ENG-SP19003-R3-GEC-redlines.pdf Markup Summary

QUALITY PLAN

**PP06**

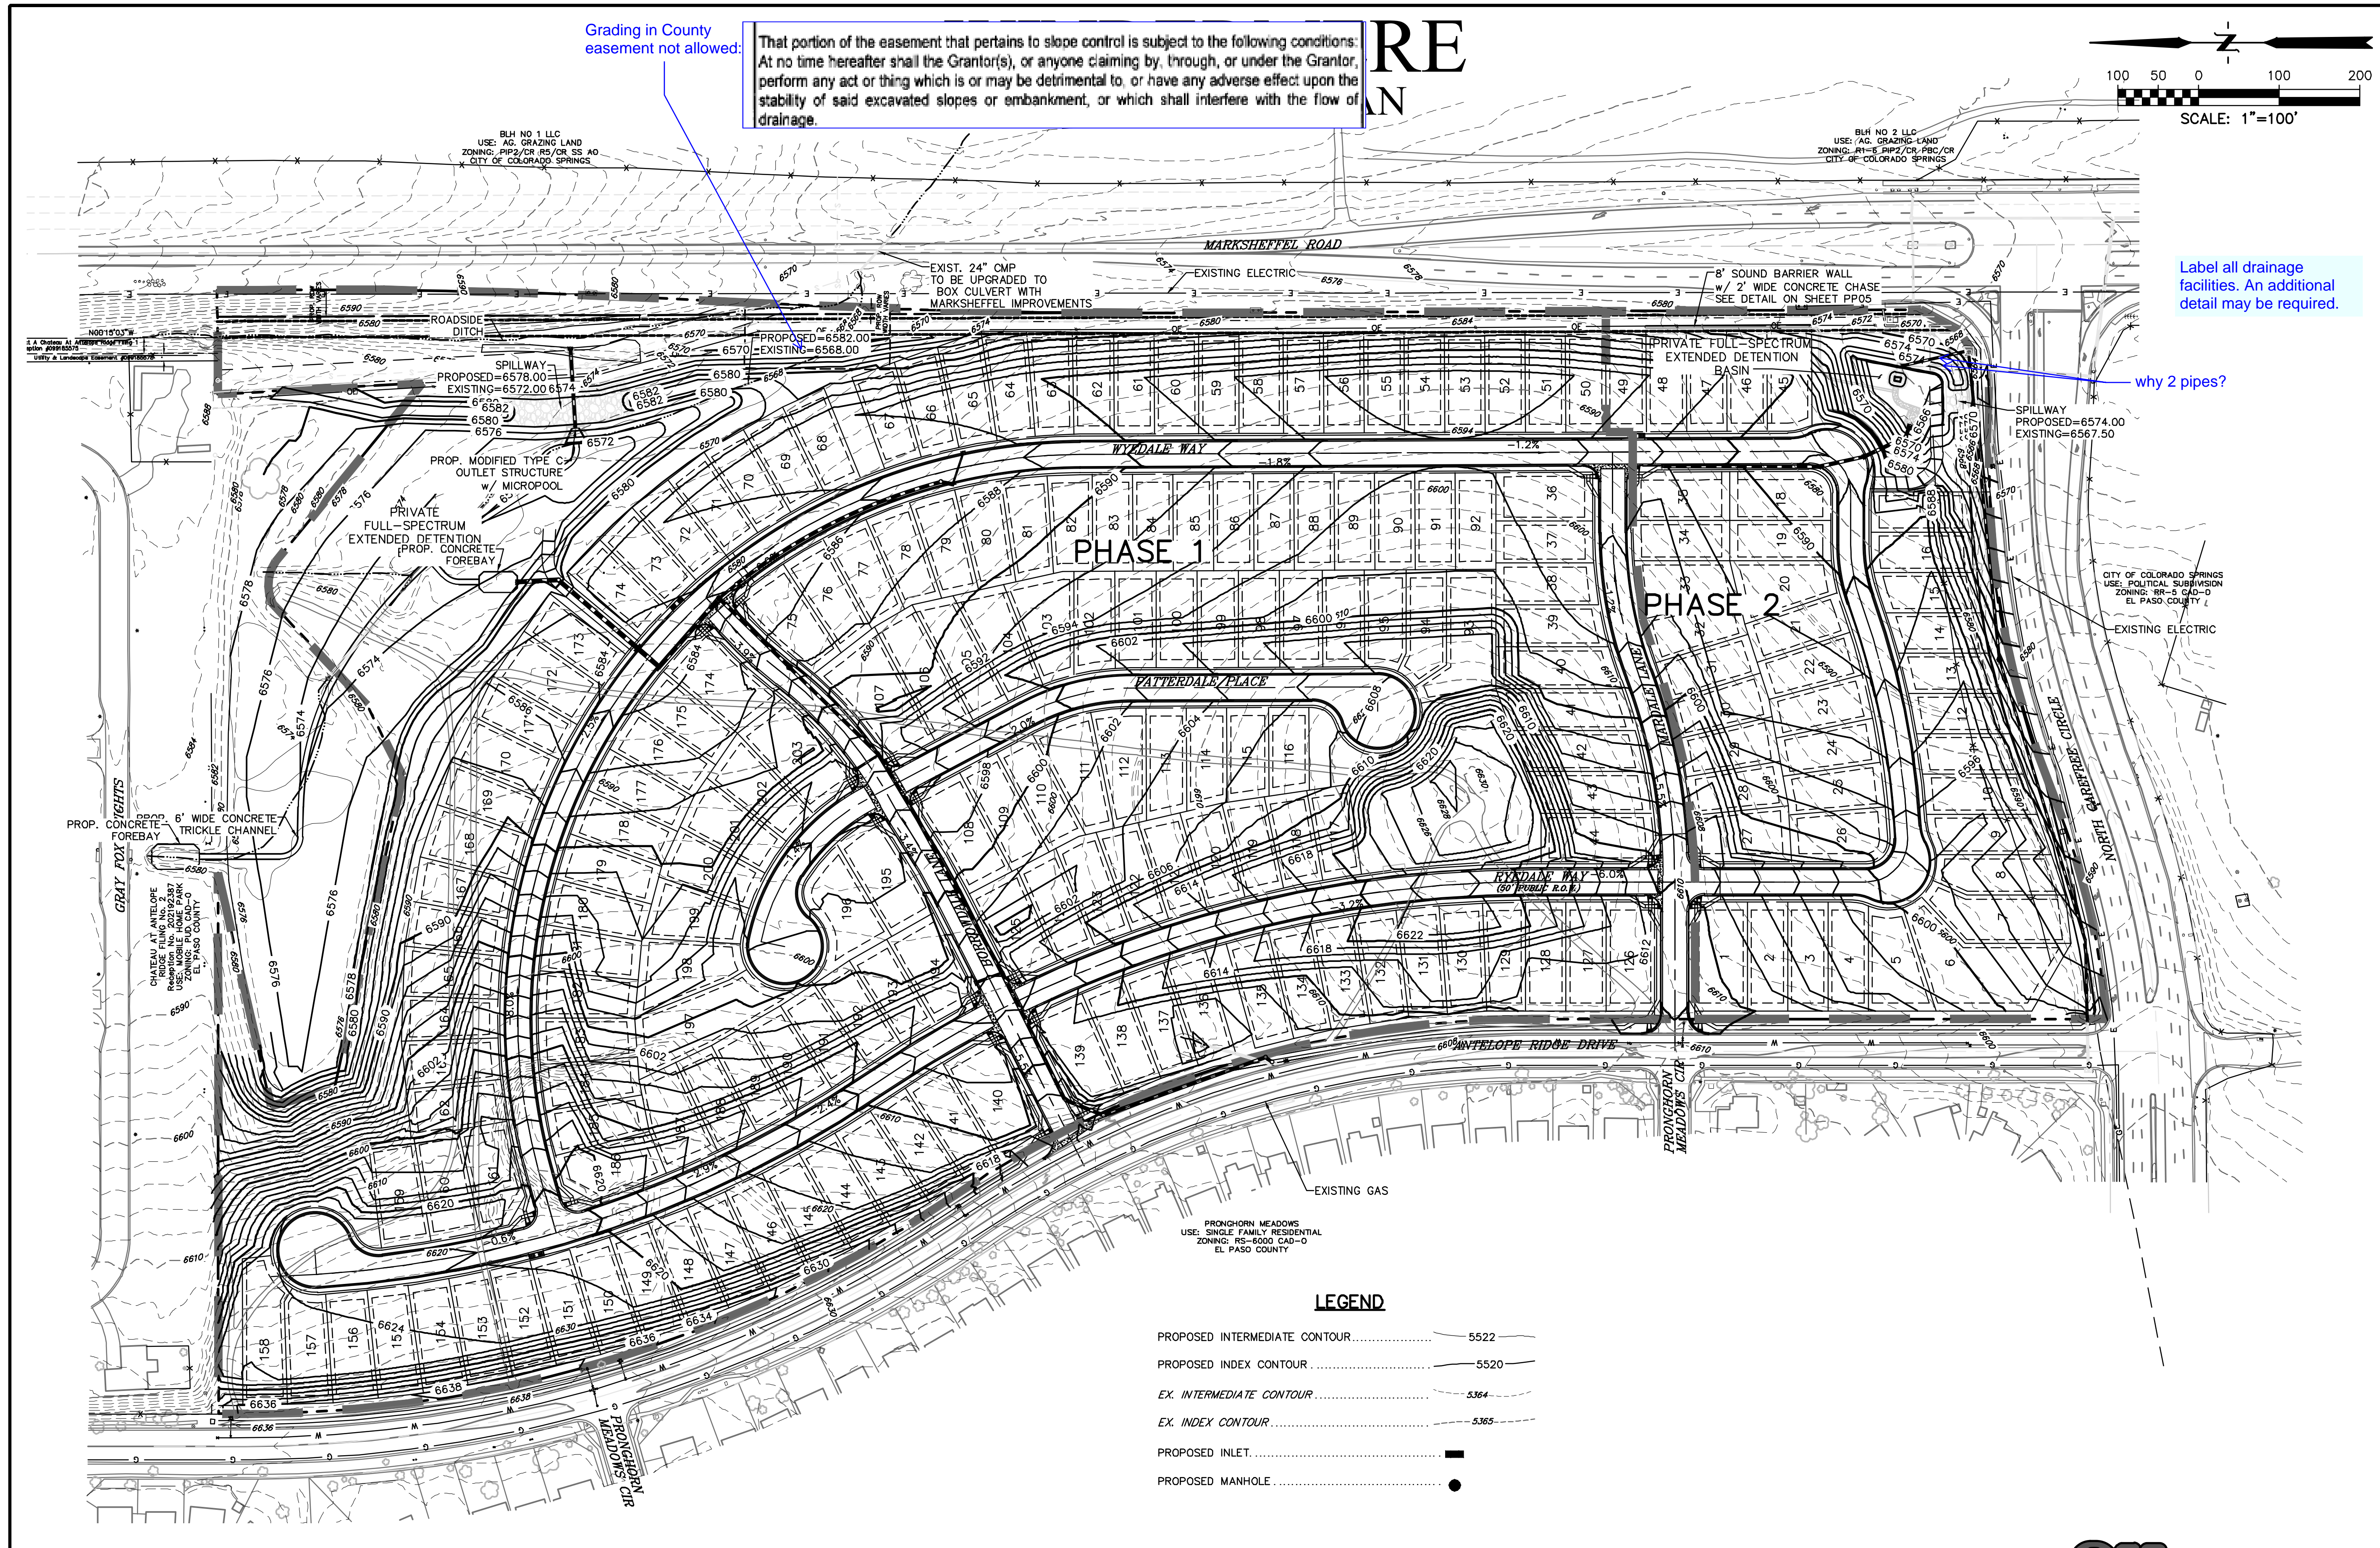
Remove grading from County easement. See Preliminary Plan comments.
